OUR REFERENCE C 199953
PLANNING APPLICATION REFERENCE: R/149/13

Application for variation of condition 3 previously approved under planning application R/221/12 – opening hours.

PROPOSED PLAN

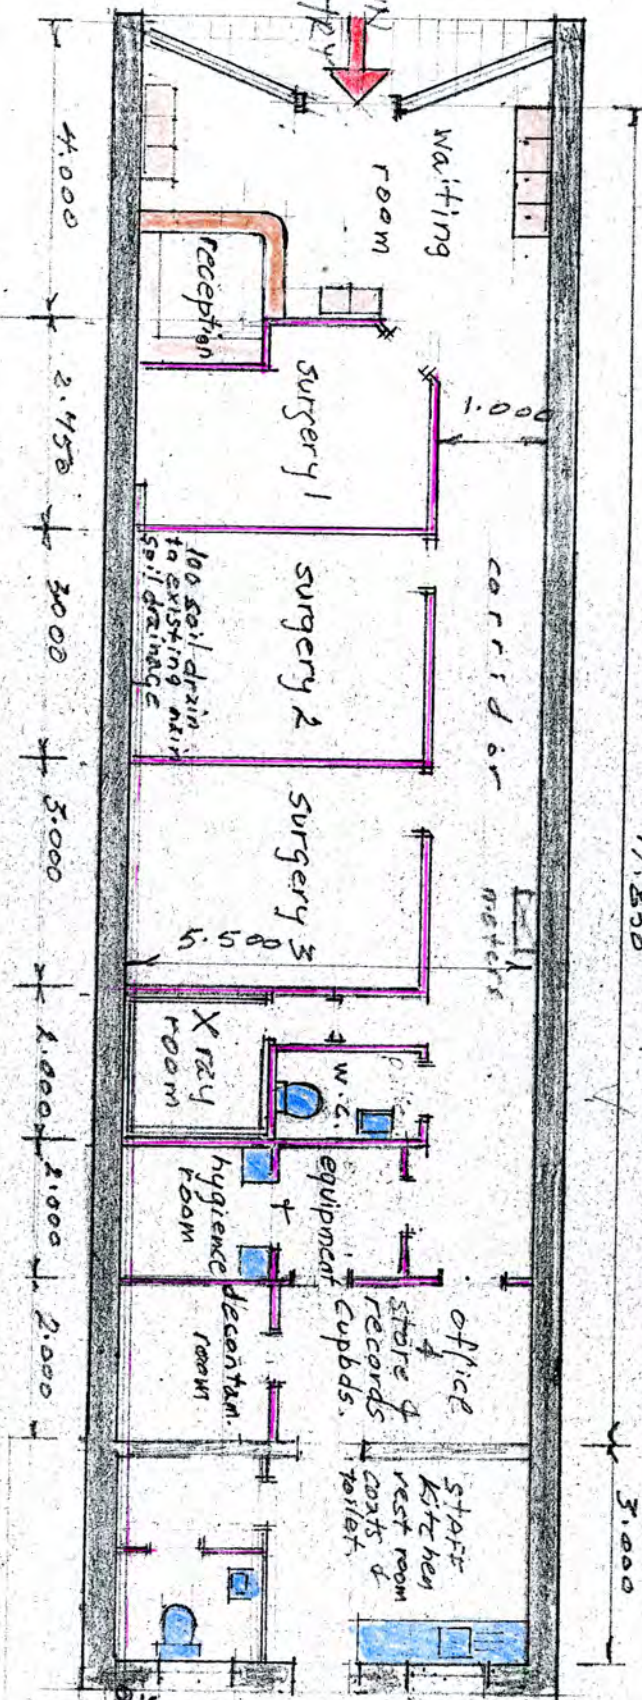
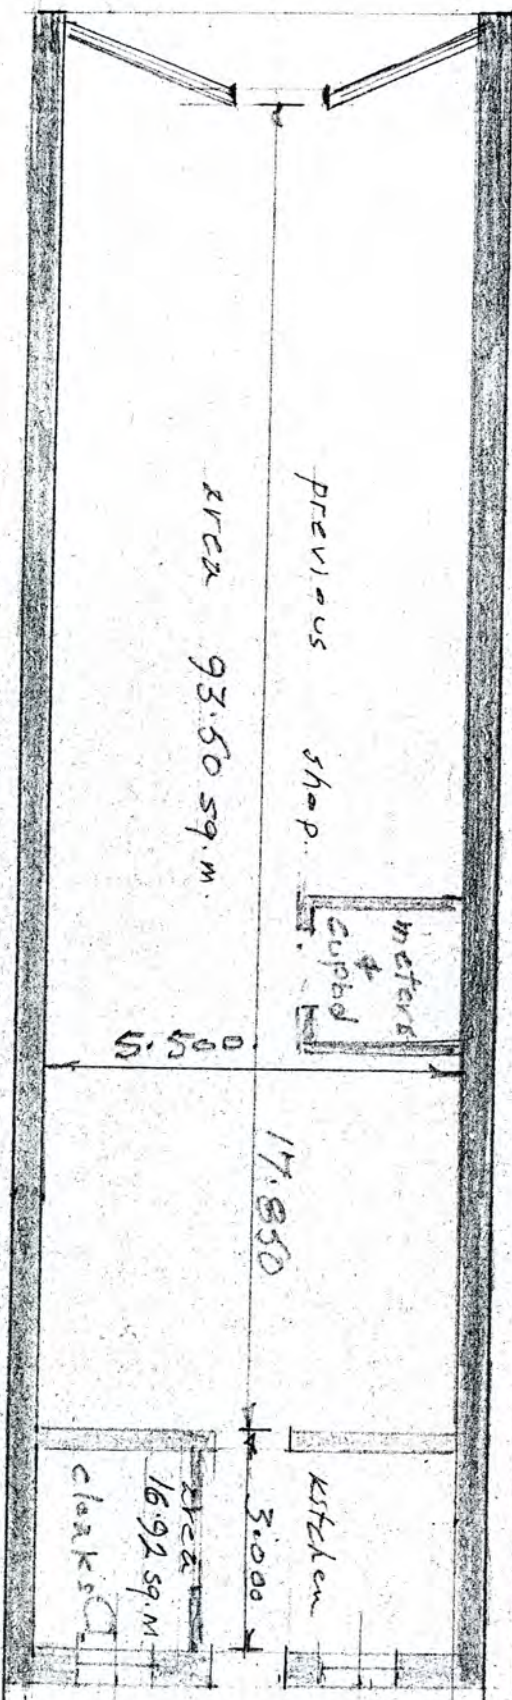
The applicant has stated in the planning statement that “the proposed surgeries will be individually soundproofed to ensure that no noise travels between surgeries or between surgeries and the waiting room or to the flats above.” It goes on to state that “A scheme of soundproofing will be designed and implemented before the proposed development is brought into use.”

On this basis there is no objection to the revision of hours provided the following condition is attached to any permission given:

The change of use hereby permitted shall not begin until full details of a scheme for sound insulation has been submitted to and approved by the Local Planning Authority. The insulation shall be installed before the premises are first brought into use and shall be maintained in an effective manner thereafter.
